Application for a non-material amendment following a grant of planning permission.

Demolition of existing conservatory, and erection of extension to dwelling

Reference number:	<input type="text" value="19/05554/FUL"/>
Date of decision	<input type="text" value="06/02/2020"/>

STS-TYB-GA-P-002 Proposed Revision B

WEST ELEVATION

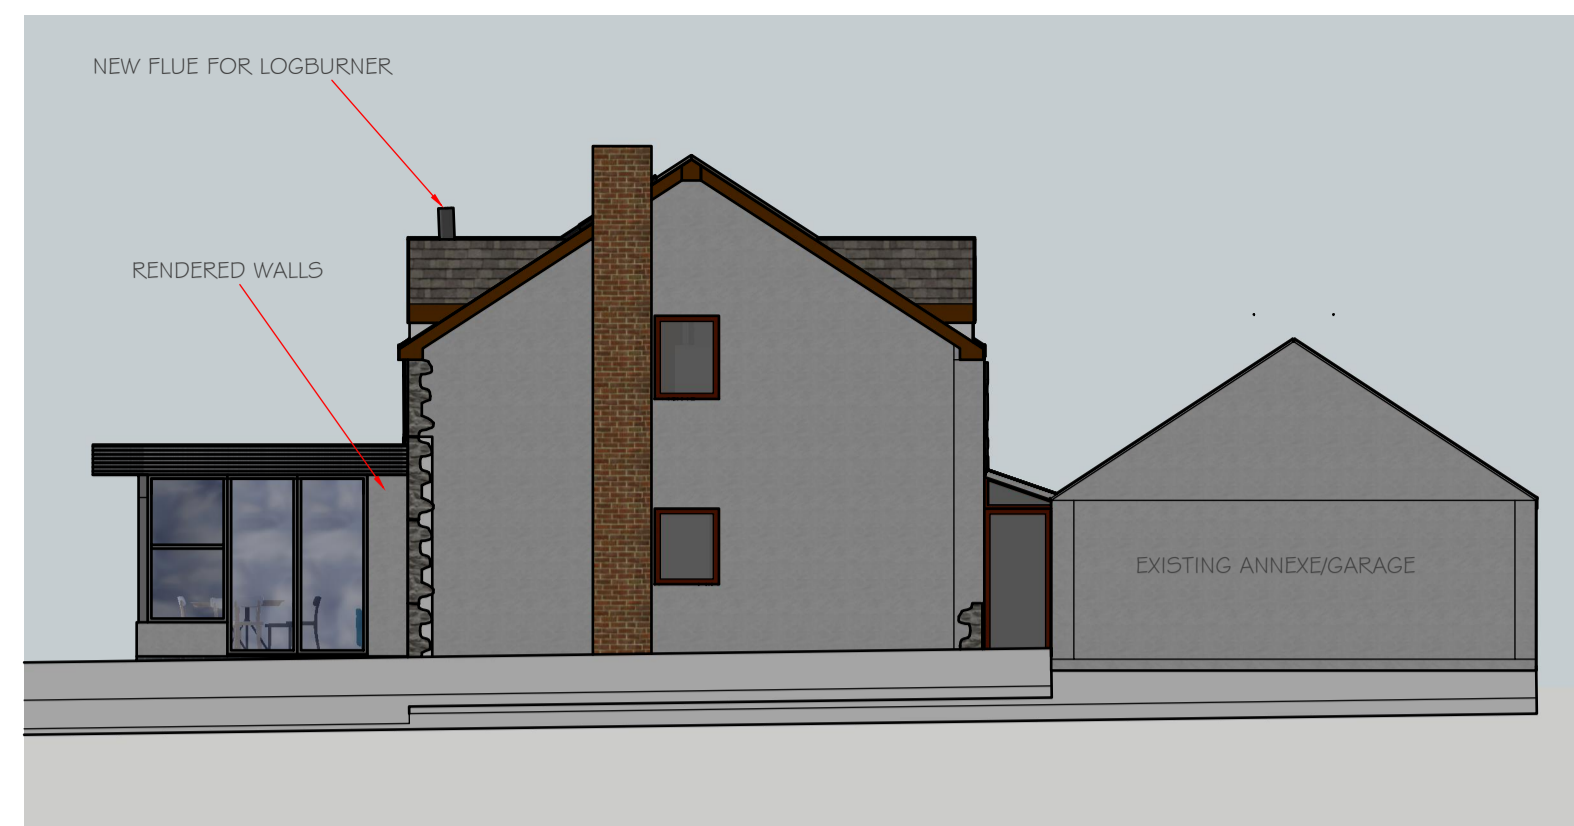
Reduction in extension footprint from 30m2 internal area (3.6m x 8.4m2) to approximately 18m2 internal area (3.3m x 5.4m)
sliding doors to west elevation replaced with picture windows
small window to north elevation removed, glazing to wrap around corner
North elevation to be timber cladding to match fascia
